January 9, 2018

RE: Waterview Sketch Plan
Updated Master Traffic Impact Study
Springs at Waterview East Preliminary Plan
PCD Project No. SKP 16-002
El Paso County, Colorado
LSC #164691

Figure 3

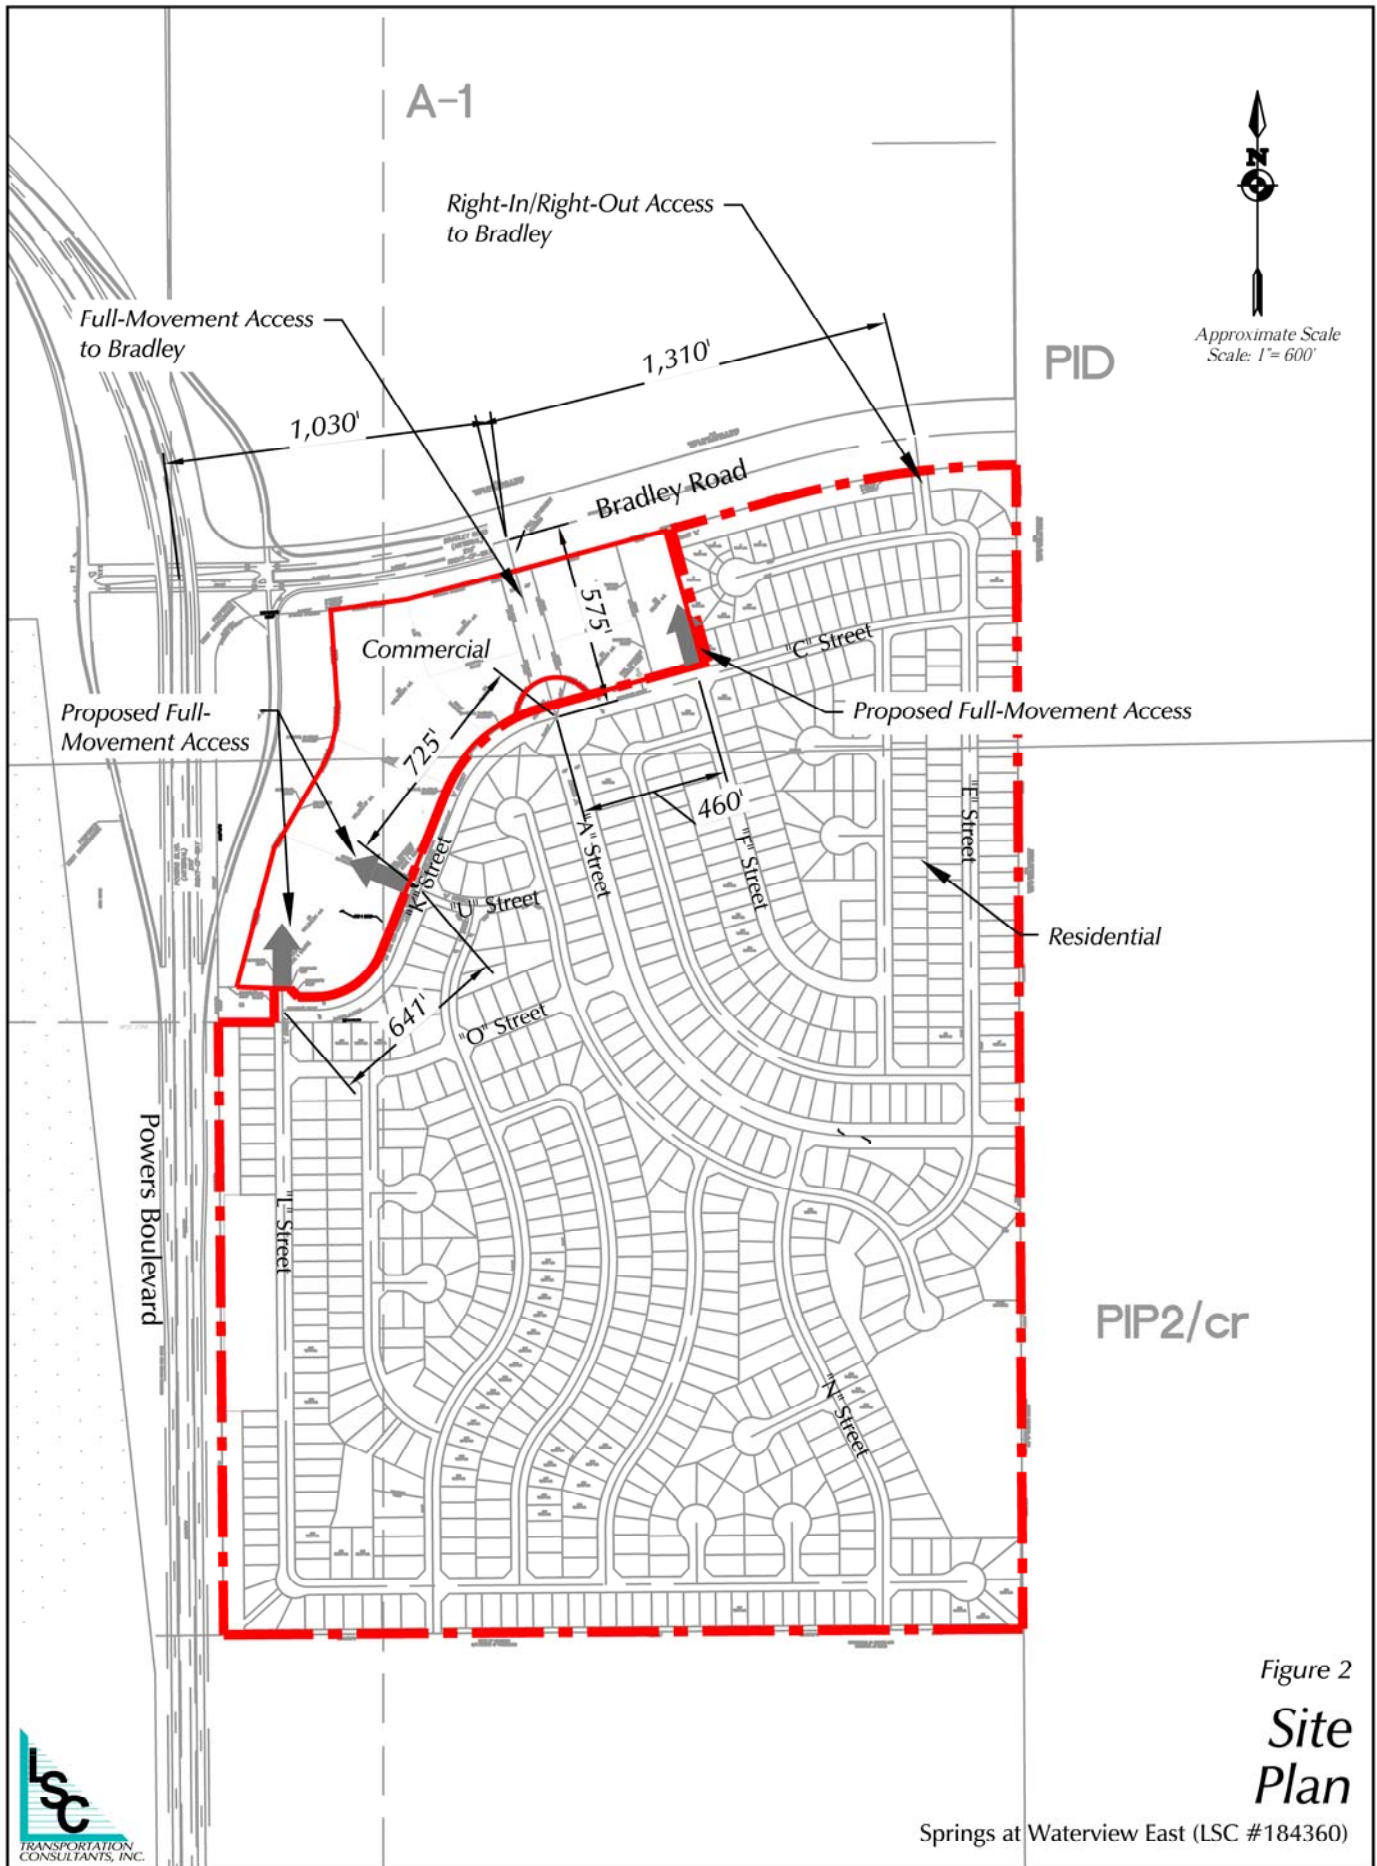
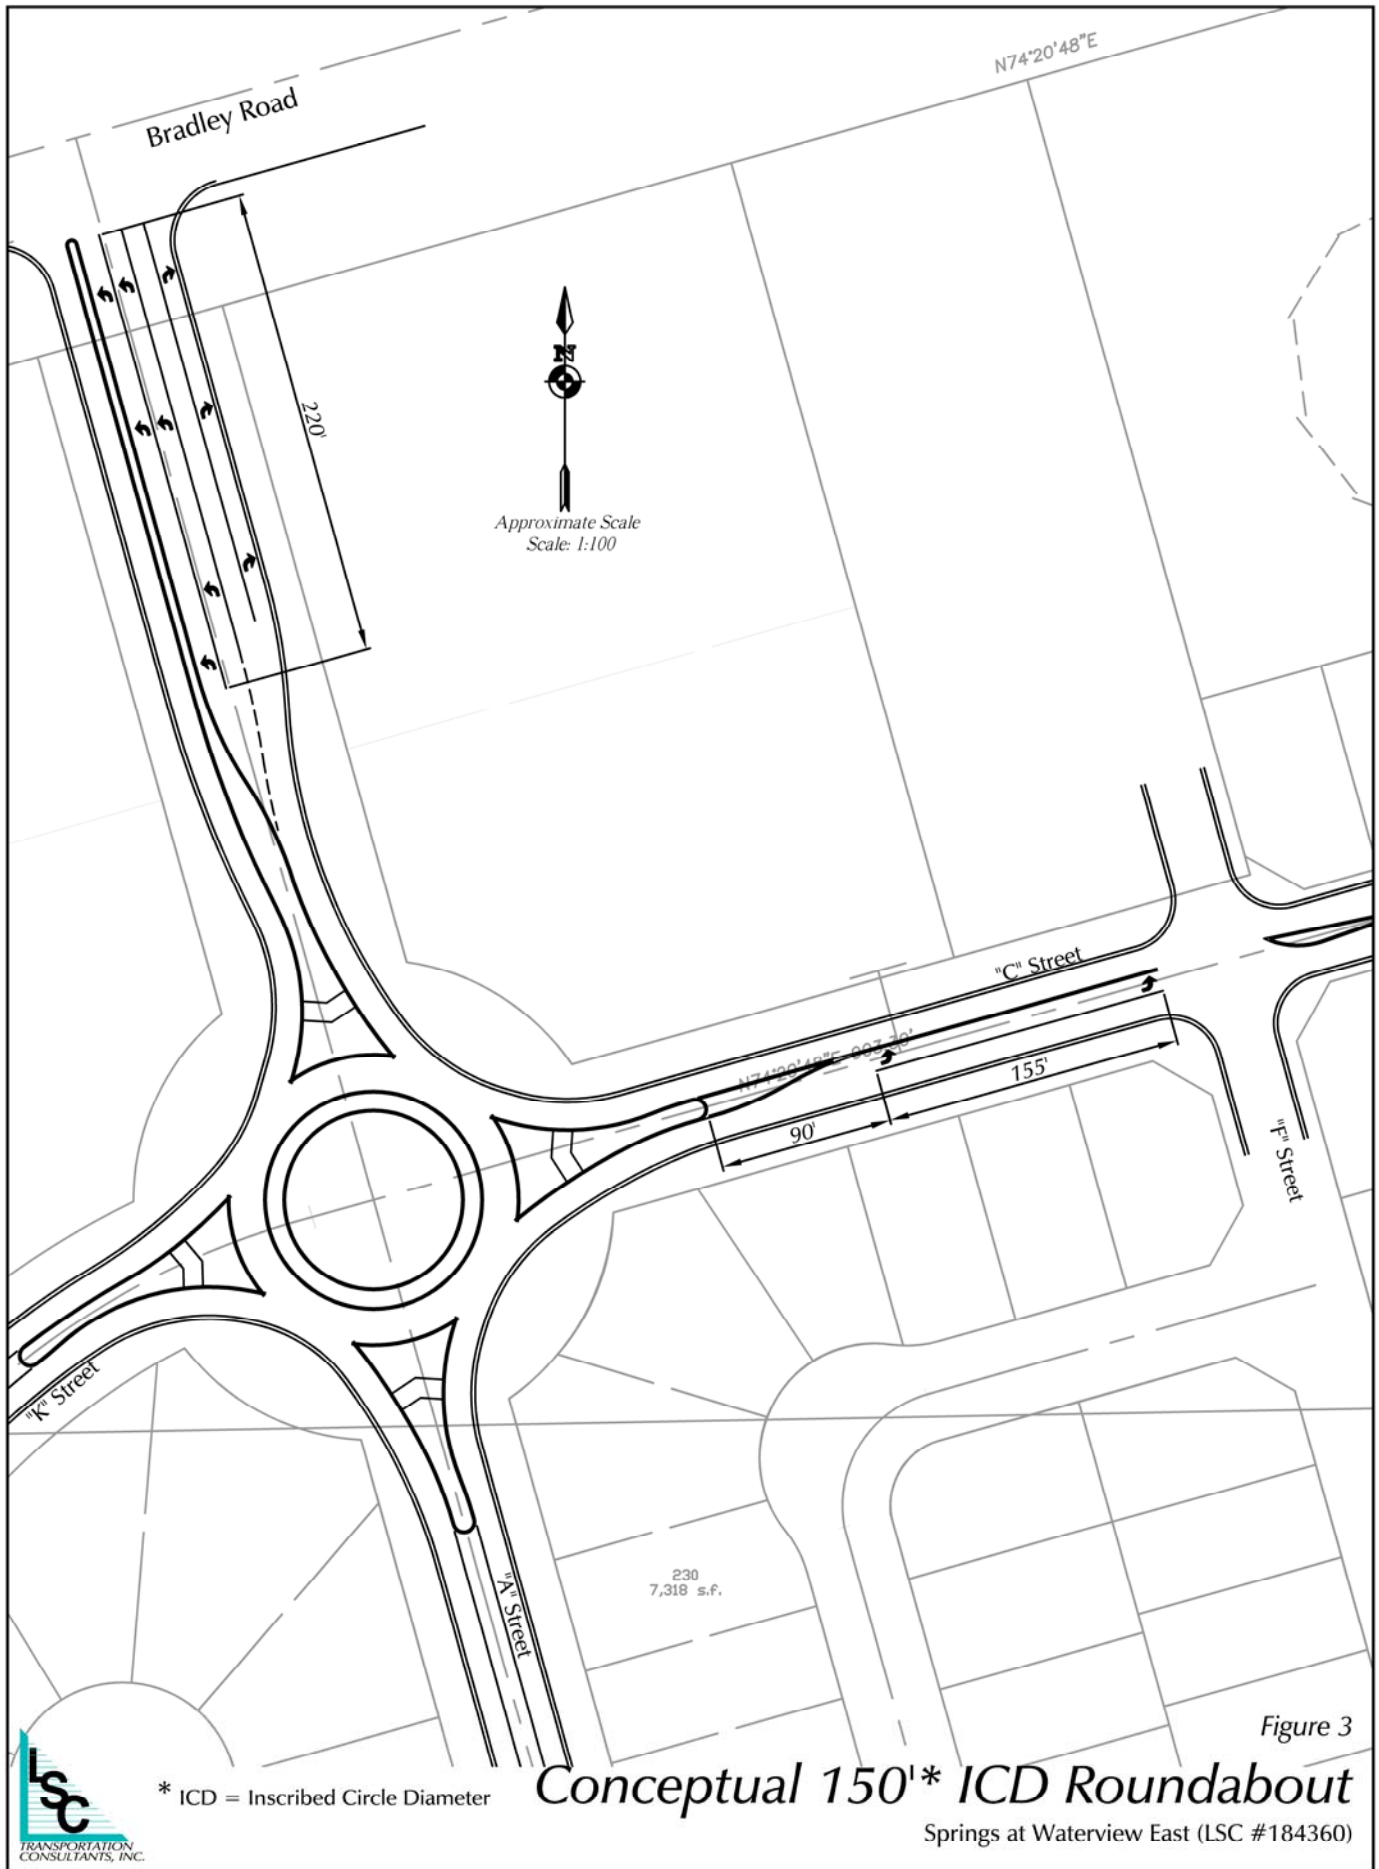
4. Provide recommendations for the proposed roundabout geometry. (What is the minimum size for the Roundabout center island?) **Review 2 clarification. Include analysis/recommendations in the report.**
